22 May 2018

Your ref: EP/7/18

Land to the Rear of Beechlands Cottages, Beechlands Close, East Preston

Proposed Site Plan, Block Plan
and Location Plan

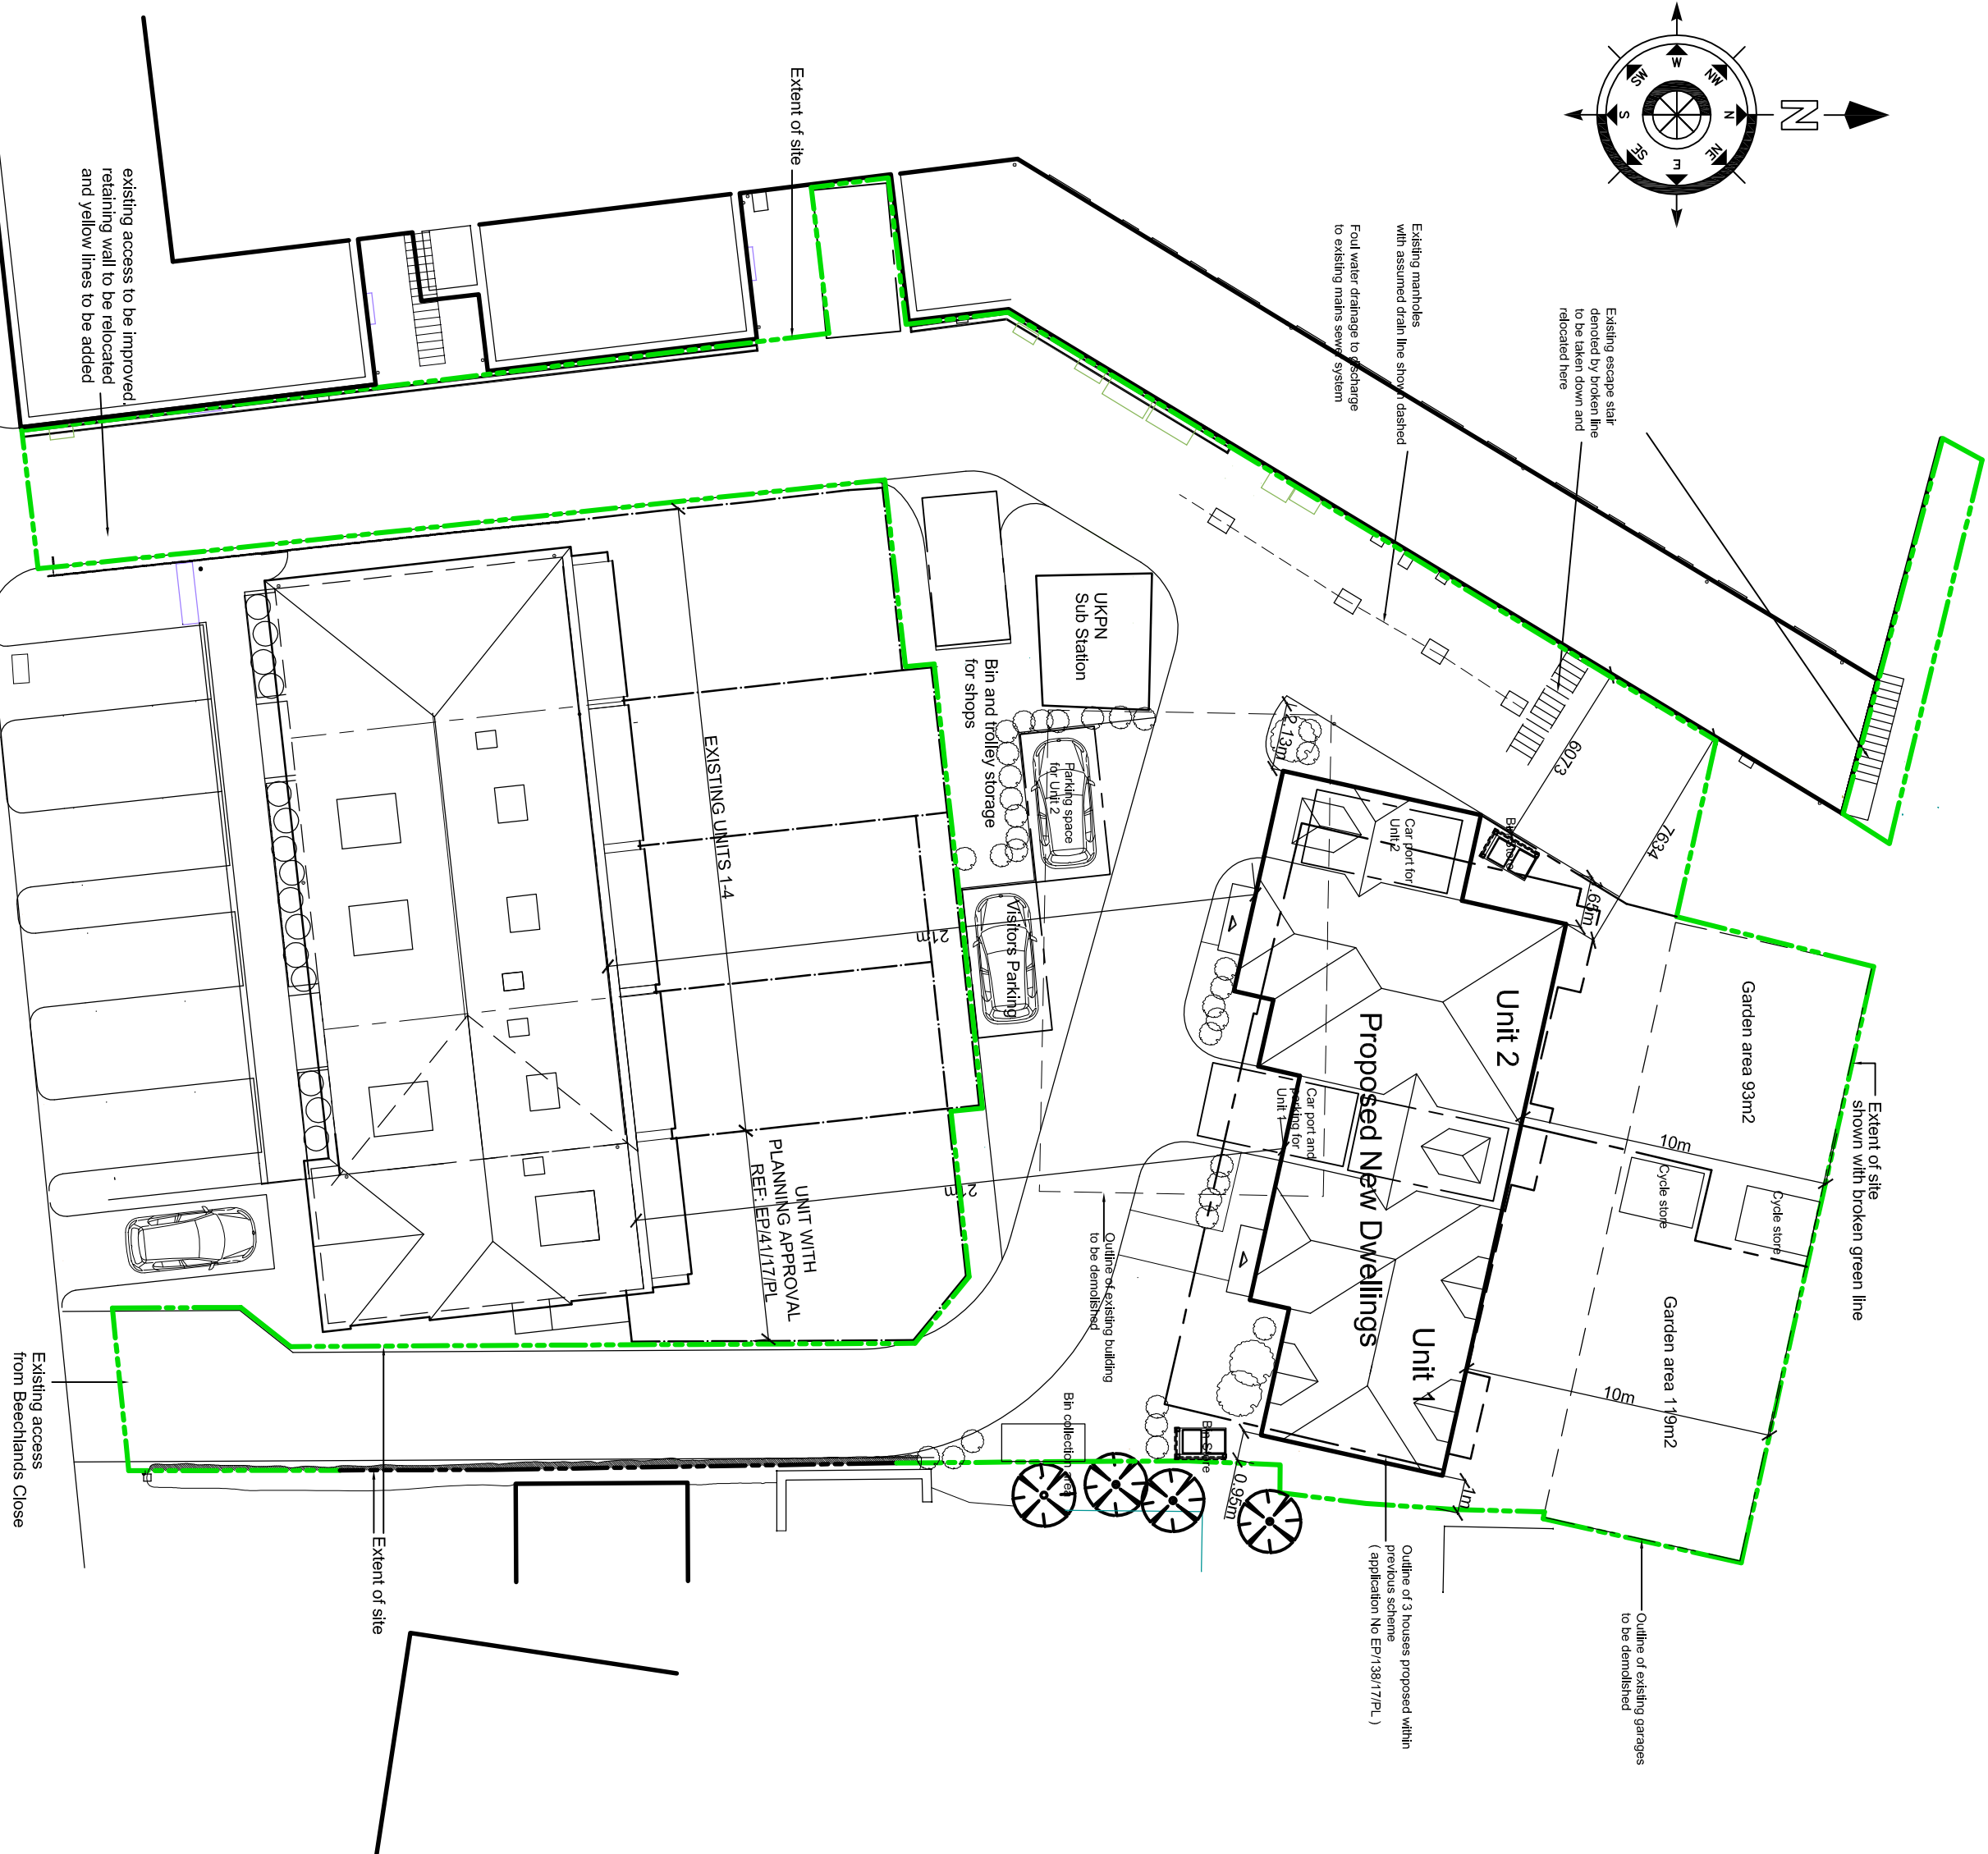
In response to your request for additional information on the drawings, the submitted drawings show the dwelling approved under application EP/41/17 but this is now annotated as such. The outline footprint of the previously withdrawn application has been added as requested.
